PLANNING APPLICATION – 22/01773/F

Erection of 6 one storey age restricted dwellings (55 years) - Blue Cedar Homes Limited

Rev	Date	Details	Rev	Status
Project	Stage	Drawing	Rev	Status
4349	3	17	F	PLANNING

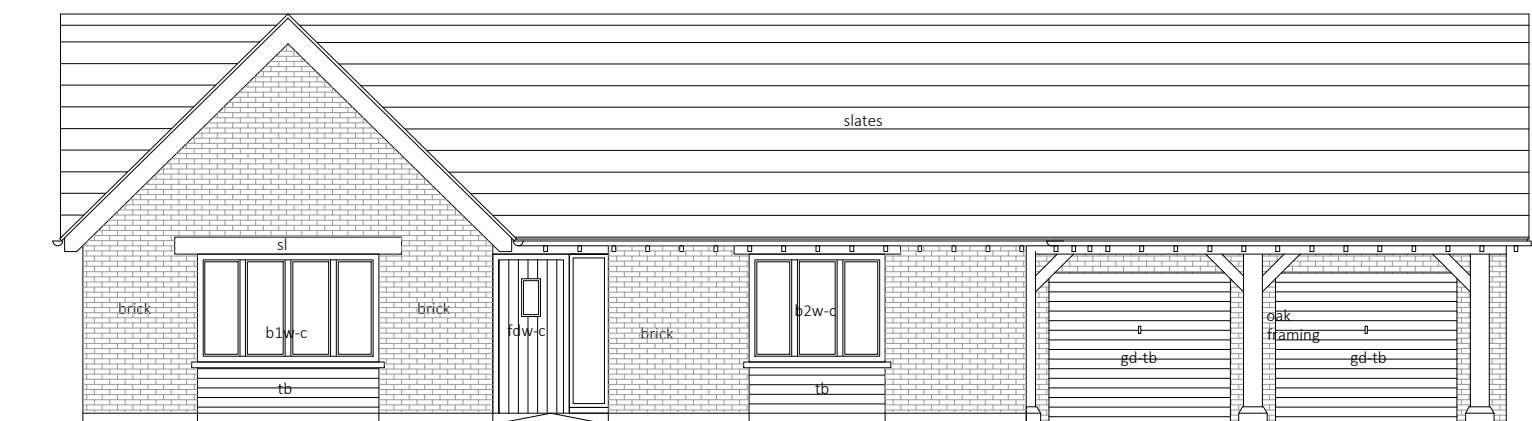
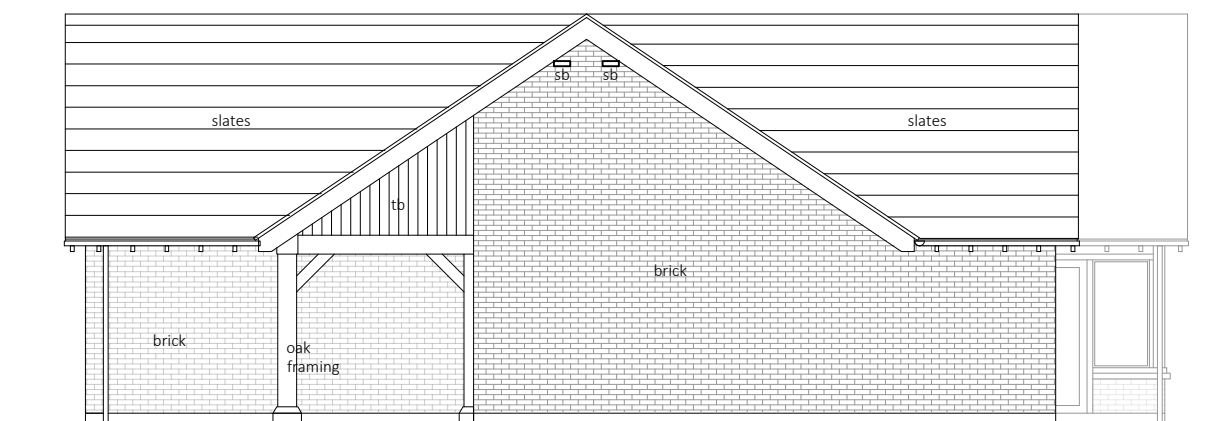
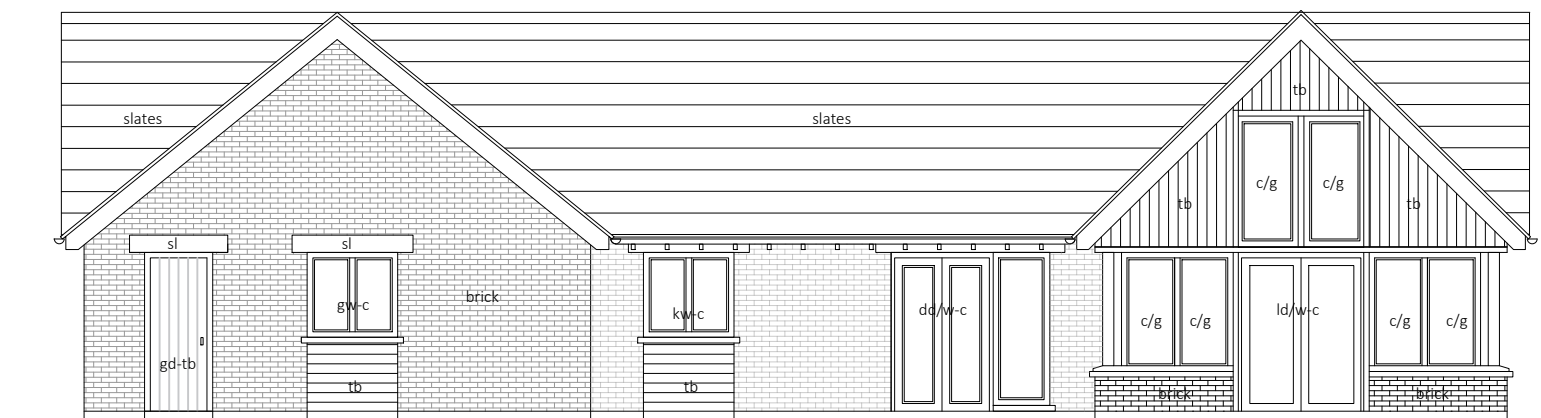
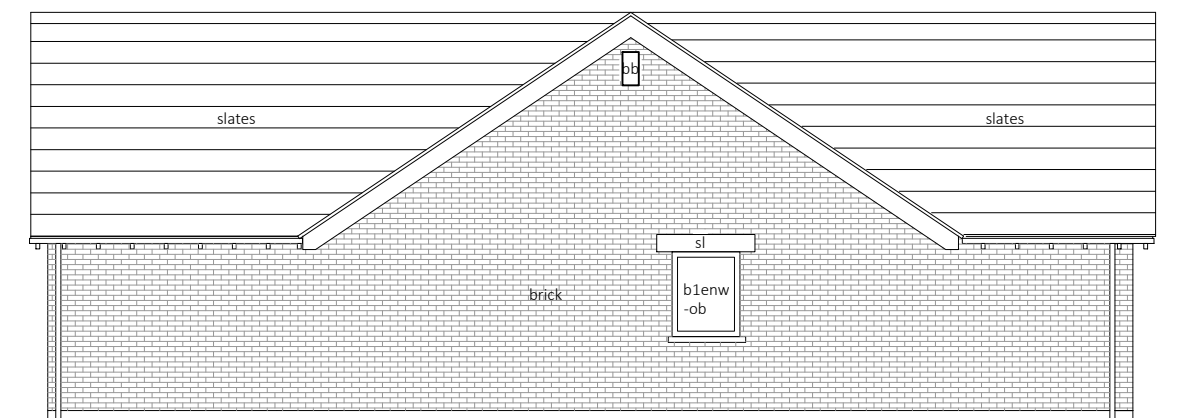
More specifically, the proposed development fails to respond to local character, landscape and surrounding context and should be refused as harming the visual and rural amenities of the area. The design, incorporating large bungalows with a variety of roof pitches, timber boarding and other uncharacteristic features is contrived and takes no design cues from the established and historic character of its surroundings. This would harm the rural character and appearance of this attractive landscape to the west of the village which is designated as a Conservation Area. Paragraph 134 of the NPPF states:
